Arun District Council  
Arun Civic Centre  
Maltravers Road  
Littlehampton  
West Sussex BN17 5LF  
Planning & Building Control General Enquiries  
Tel: (01903) 737756 Fax: (01903) 730442  
Dx: 57406 Littlehampton  
Minicom: 01903 732765  
e-mail: [planning@arun.gov.uk](mailto:planning@arun.gov.uk)  
website: [www.arun.gov.uk/planning](http://www.arun.gov.uk/planning)

Application No: FP/179/20/PL  
Site Address: 7 Ambleside Close Felpham PO22 8NG  
Description of works: 1 No 3 bedroom detached chalet bungalow. This site is in CIL Zone 4 and is CIL Liable as new dwelling.

Thank you for your internet representation made on 6th October 2020 which has been recorded as an objection with the comments as follows:

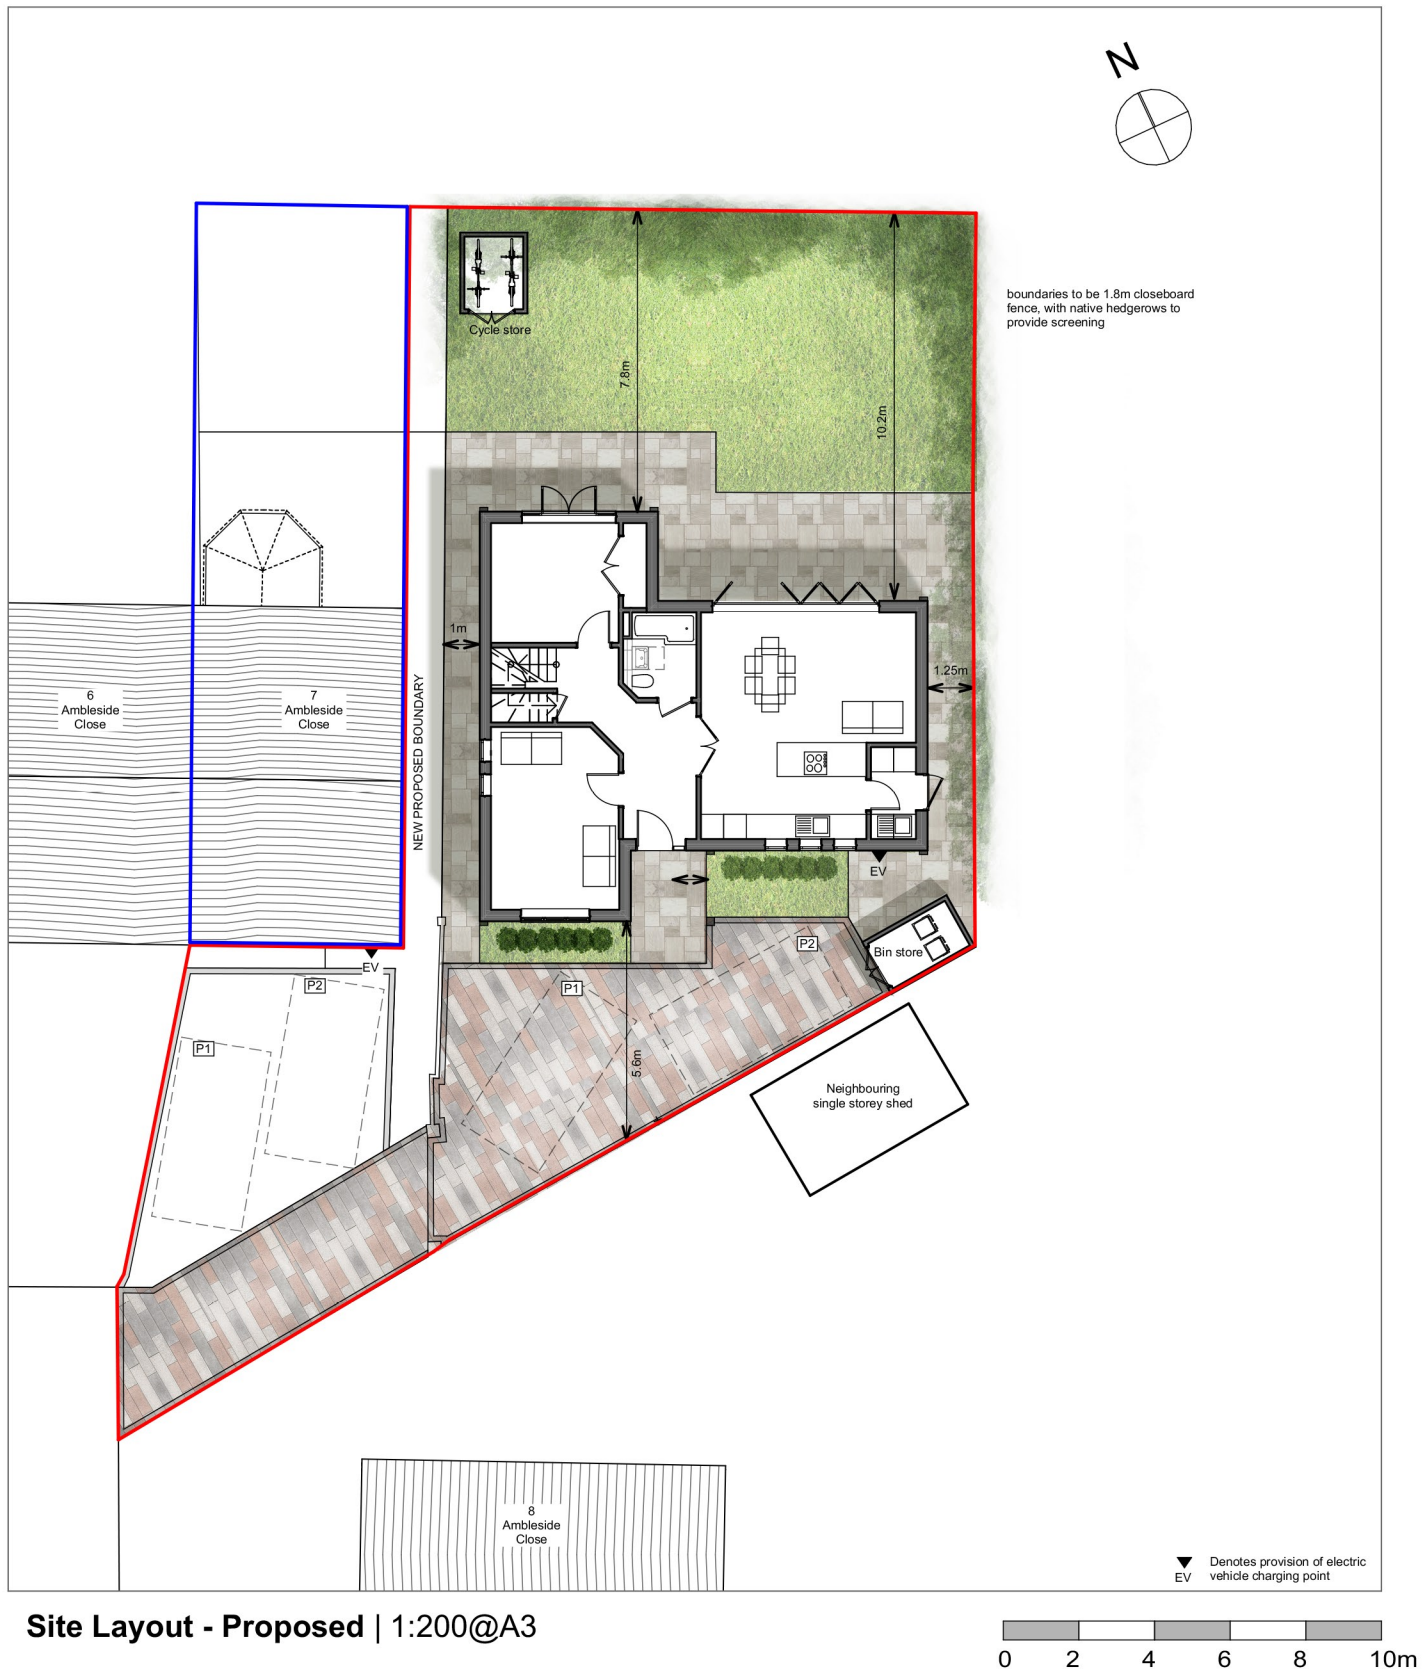
1. There is limited on road parking already in the close & I do not believe there is adequate off road parking proposed for the existing property along with the new build. This will cause further congestion in the close restricting access from Outerwyke Rd for emergency vehicles etc.
2. Site access would be difficult for the delivery of materials, services, plant machinery & construction workers due to the number & width of driveways in that specific area & the size of the close which could lead to damage to other residents property.
3. During heavy rainfall the bottom end of the close in front of the proposed new build already floods.
